Online Comment

Application H02-0837-25
Location The Manor House 5 East Street Crowland PE6 0EN
Proposal External & Internal Alterations

Name Ruben Lopez, Historic Environment Officer
Address Lincolnshire County Council County Offices, Lancaster House LN1 1YL

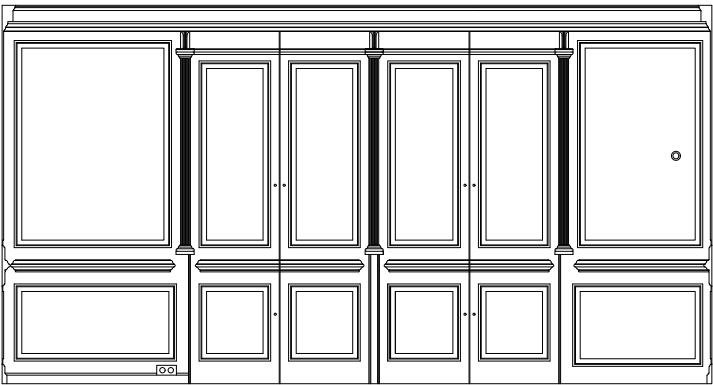
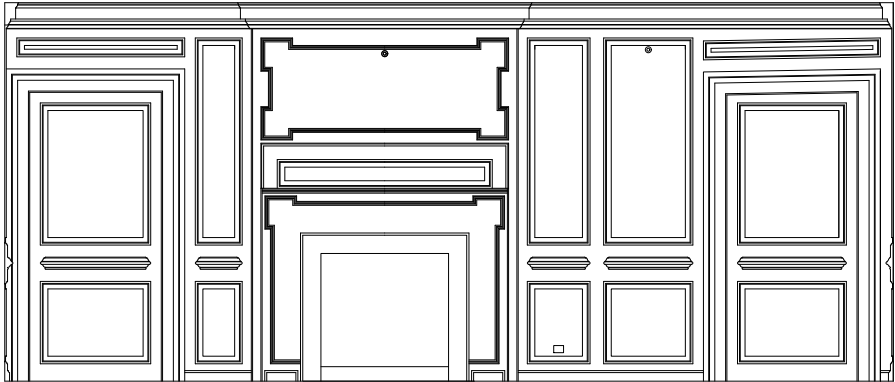
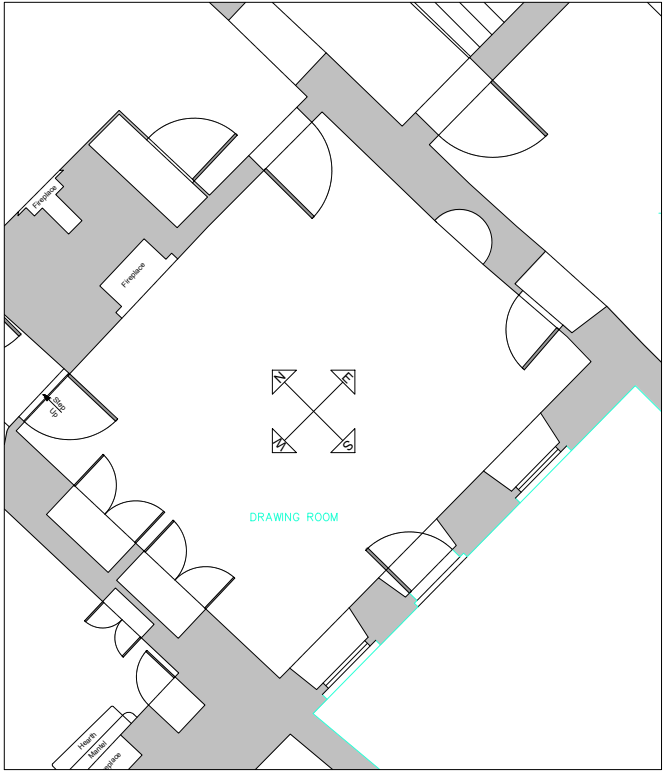
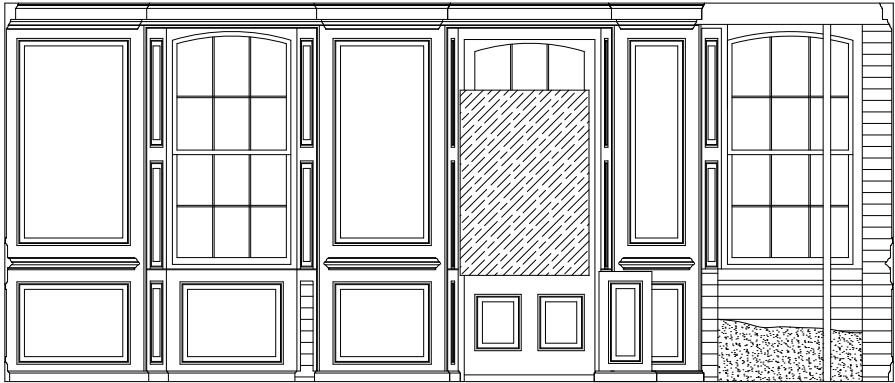
The proposed development comprises 'External & Internal Alterations'. Including Internal alterations allowing for removal and reinstatement of wall panelling and floorboards in 3 no. rooms to facilitate structural investigations. This might have a significant impact on any surviving fabric elements, resulting in total or partial loss, if present. NPPF (paragraph 218). We therefore recommend that if permission is granted, there be an archaeological condition for a mitigation strategy to effectively deal with this site.

A programme of archaeological monitoring during works affecting the designated building, particularly where any structural material is to be removed, is recommended as a mitigation strategy and as a complement to the detailed information submitted as part of the heritage impact assessment.

This will comprise a phased programme of archaeological mitigation work including but not limited to a continuous archaeological monitoring (watching brief) to enable protect and preserve the significance of the Manor and record any exposed unknown significant fabric elements.

This should be secured by South Holland District Council's standard conditions AR01, 02 and 03 and is in accordance with National Planning Policy Framework paragraphs 207 and 218 and the South East Lincolnshire Local Plan (Policy 29).
